Re: Blake's Lotaburger #27 Drive-Thru
2301 Carlisle Blvd. NE
Traffic Circulation Layout
Architect's Stamp 06-30-2022 (H16-D106)

The TCL submittal received 07-01-2022 is approved for Building Permit with. A copy of the stamped and signed plan will be needed for each of the building permit plans. Please keep the original to be used for certification of the site for final C.O. for Transportation.

RE: Blake's Lotaburger #27 Drive-Thru | Traffic Circulation Layout Review letter dated June 21, 2022.

1 SITE PLAN - TRAFFIC CIRCULATION LAYOUT
1" = 20'-0"

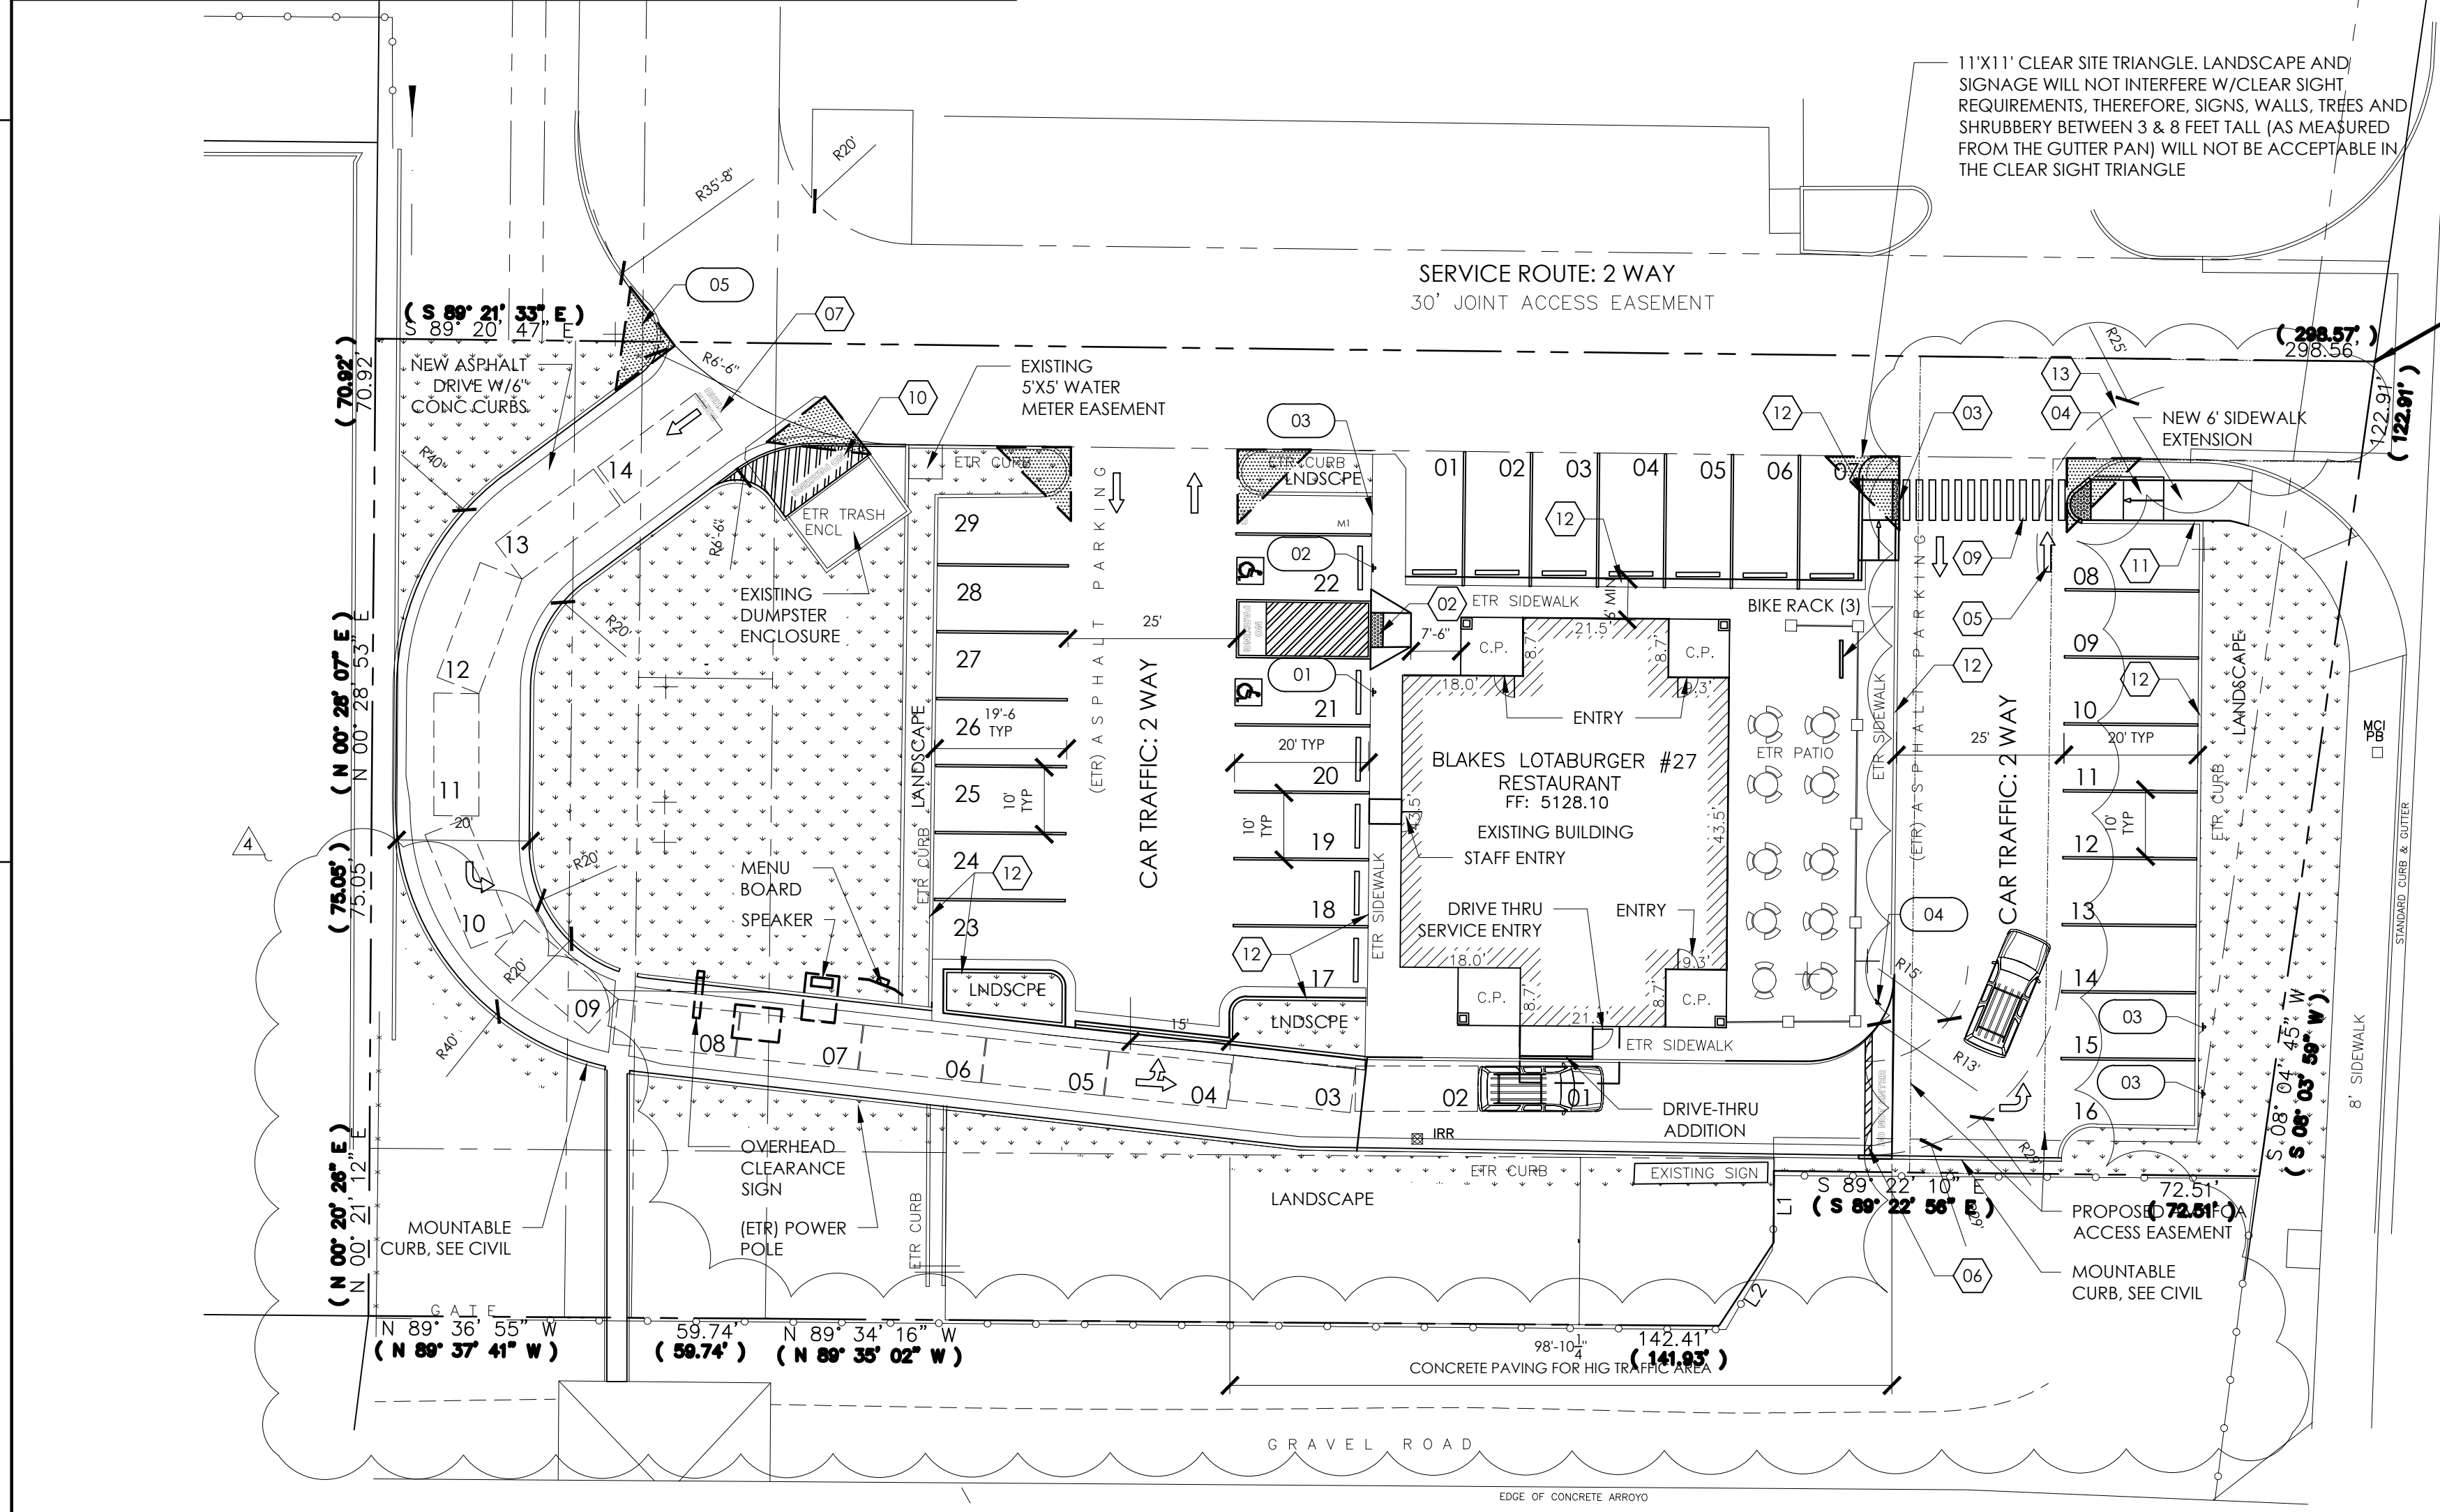
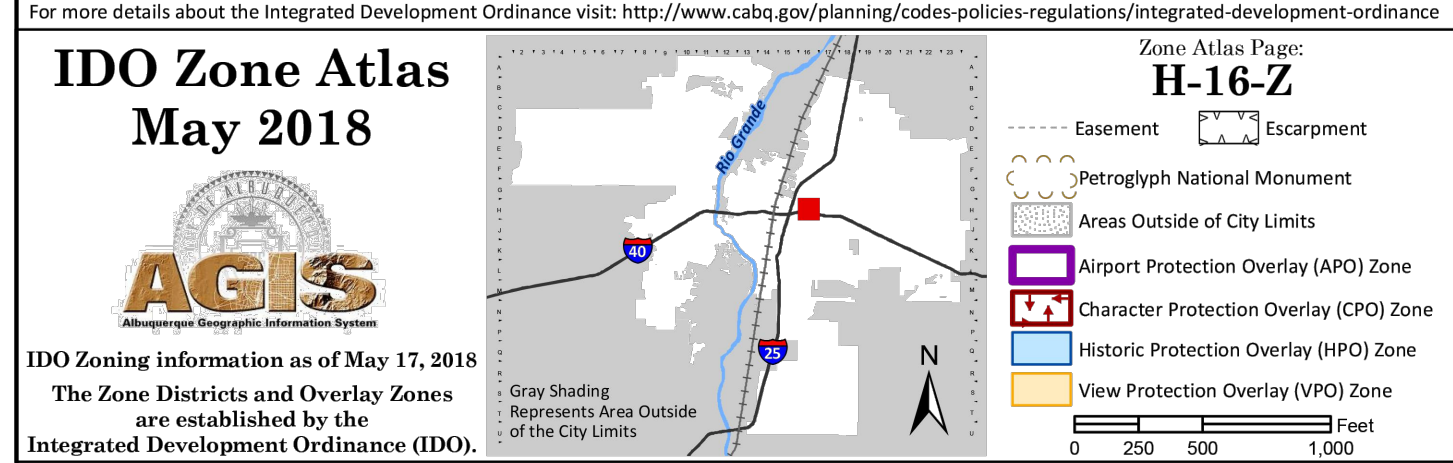
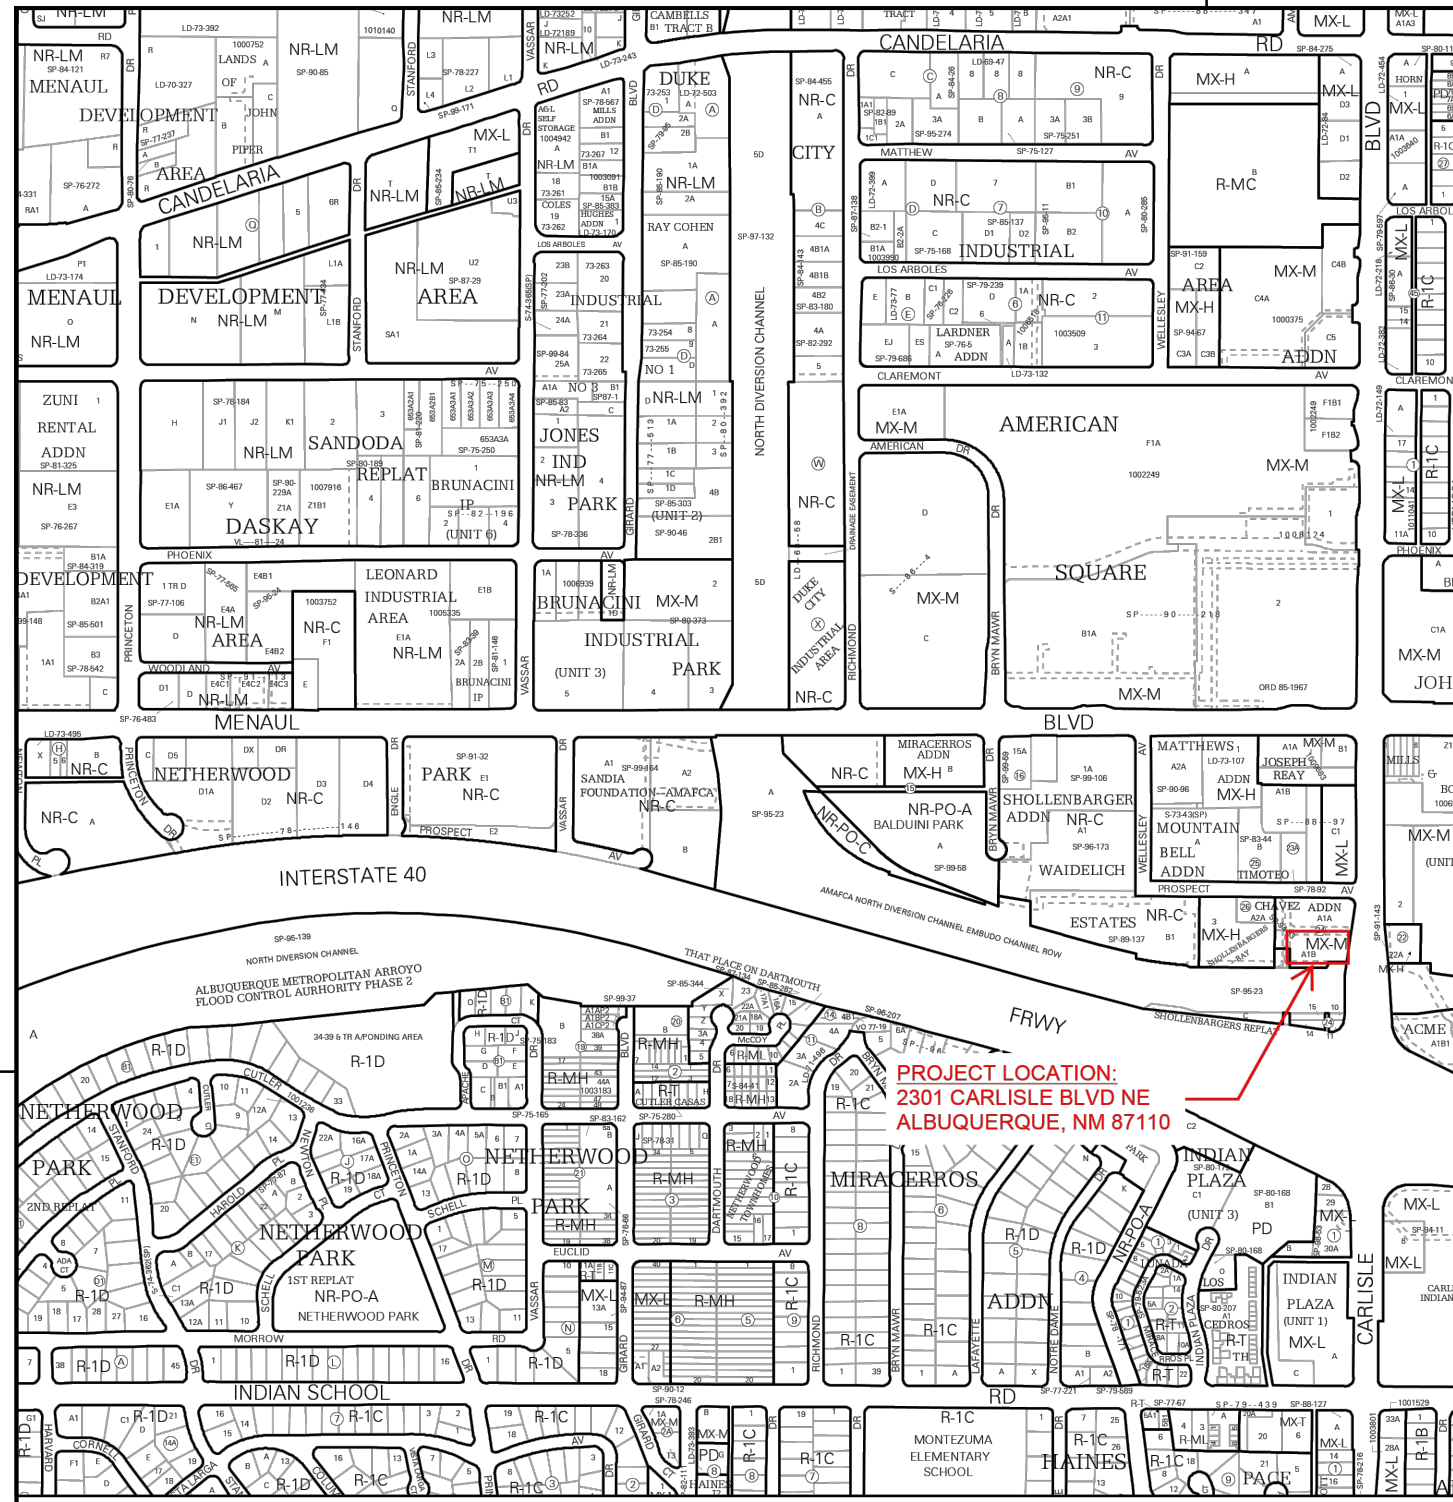
1. Vicinity Map:
 - a. Vicinity Map provided on Sheet AS-104, titled, "Project Access"
2. Parking Requirements:
 - a. See Sheet AS-104, right column labeled, "Parking Requirements"

6. Proposed Drive-Thru Bypass:
 - a. Bypass has been replaced with keyway required for dead-end parking.
7. ADA Curb Ramp:
 - a. Keynotes 01, 02, and 03 added to refer to ADA Ramp configurations on AS-103.

- a. Keynotes added to clarify detail locations on the TCL plan.
- 9. Pavement Markings + Striping:
 - a. Refer to details D1, D2, and D3 on Sheet AS-103 for pavement marking details. Striping to be per layout on plan. Keynotes added to refer locations of specific details. Lettering height to be typical for all.

- 10. Easements + Rights of Way
 - a. Existing easements and rights of way are now identified on the plan, specifically:
 - i. Carlilse Boulevard + Median (R.O.W. Varies)

- 15. Bicycle Rack Mounting
 - a. Bicycle rack will be sturdy and anchored to concrete pad, see detail B4/AS-103.
- 16. Bicycle Clear Area
 - a. Clear area of 1' around the parking stall is provided. See outline on TCL plan.

- a. Drive Aisle widths and radii provided on TCL plan.
- 19. Drive Aisle Dimensions
 - a. Main Circulation Road: 24' min. required: 30' Joint Access provided (Existing to Remain)

- b. Two Way Traffic: 22' min. required: 25' provided in parking areas
 - c. Fire Lane: 20' min. required. Existing 25' Fire Lane to remain.
- 20. Turn Radii

- a. Radii dimensions added for all turns. Existing fire truck path to remain, path now showing on the TCL.
- 21. Keyway for dead-end parking:

- 31. Intersection Sight Distance Exhibit
 - a. Provided per Detail, 3/AS-104. Area in prescribed triangle (per DPM) is free from any visual obstruction.

- b. Note: this access has been recently permitted through NMDOT as part of this process (due to proximity to I-40)
- 32. Clear Sight Triangle
 - a. Clear sight triangle and notes moved to intersection of Access road and Carlisle.

SITE DETAILS

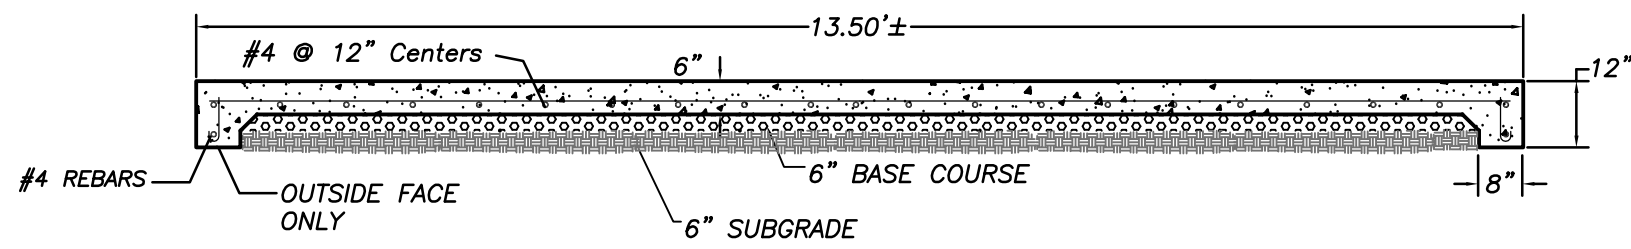
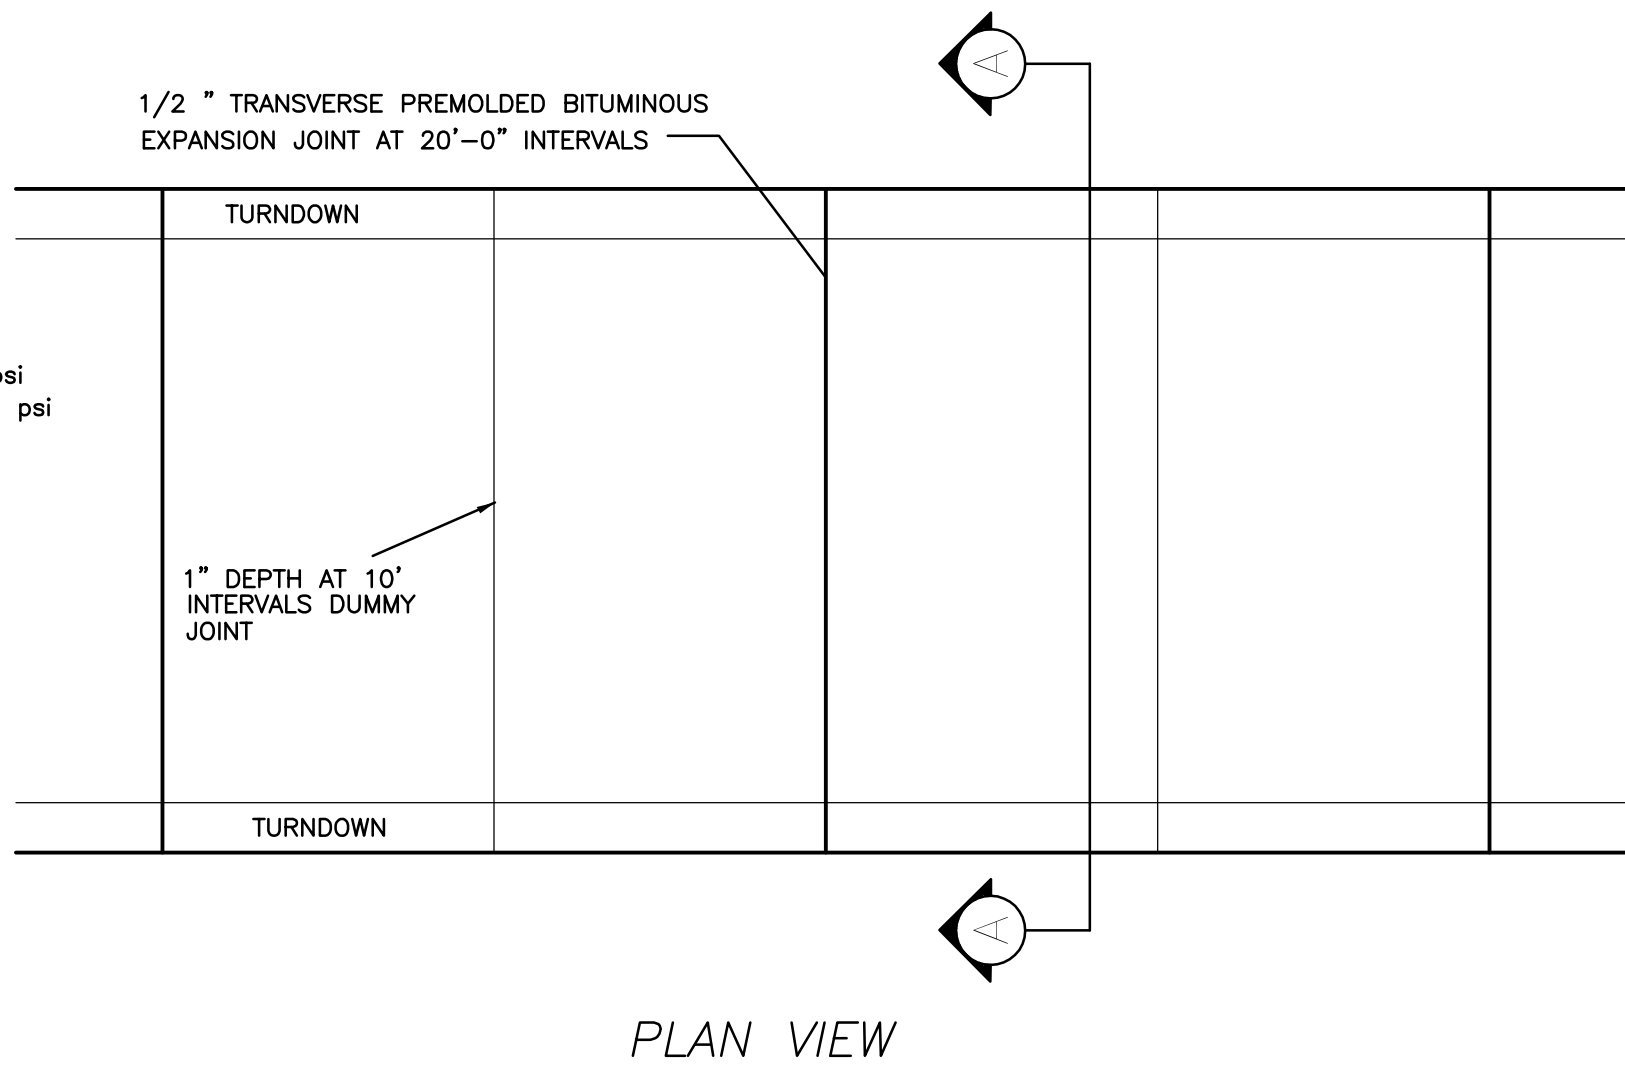
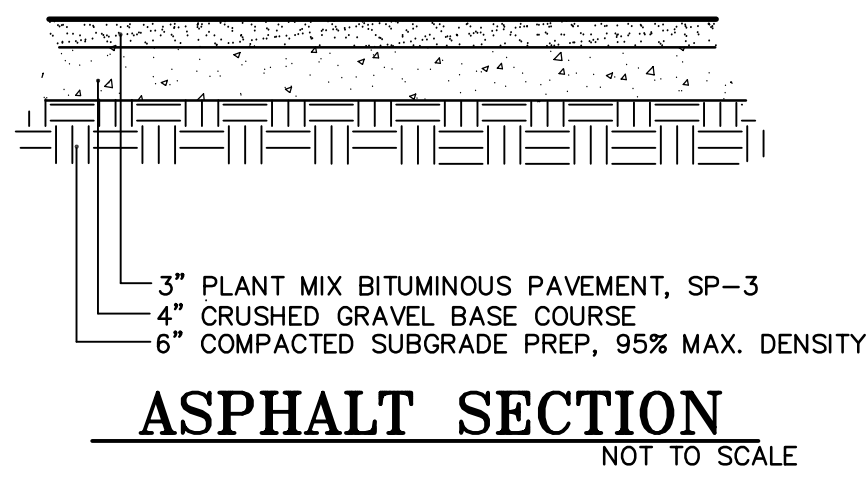
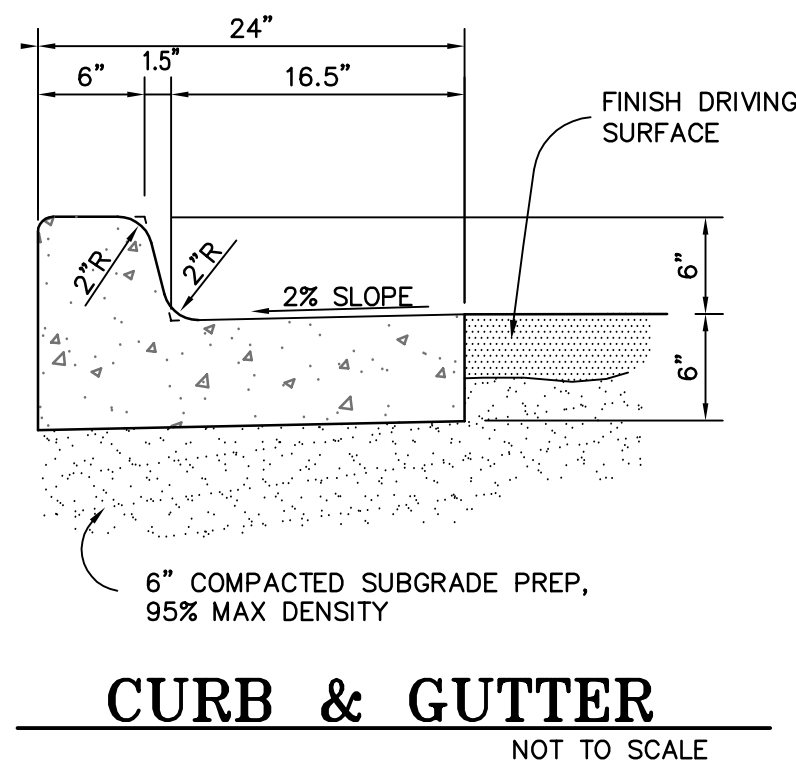
- b. Additional sidewalk ramp provided for access onto Blake's property.
- 13. Motorcycle Parking Signage:
 - a. Free-Standing signage #03 added to read, "Motorcycle Parking Only." See detail A1/AS-103.

- b. Pavement marking to read, "MC." See detail D3/AS-101.
- 14. Bicycle Racks
 - a. Bicycle rack specified meets the established guidelines. See Keynote 01 on Sheet AS-104 and Detail B4/AS-103.

- 22. ADA Pedestrian Pathway
 - a. Pathway outlined on TCL plan. From the sidewalk along Carlisle, turn West and go down new curb ramp (Detail B3/AS-103) to cross parking lot along striped pedestrian walkway (Detail D1/AS-103) and up new curb ramp in existing island (Detail C3/AS-103) into building at existing Northeast entrance.
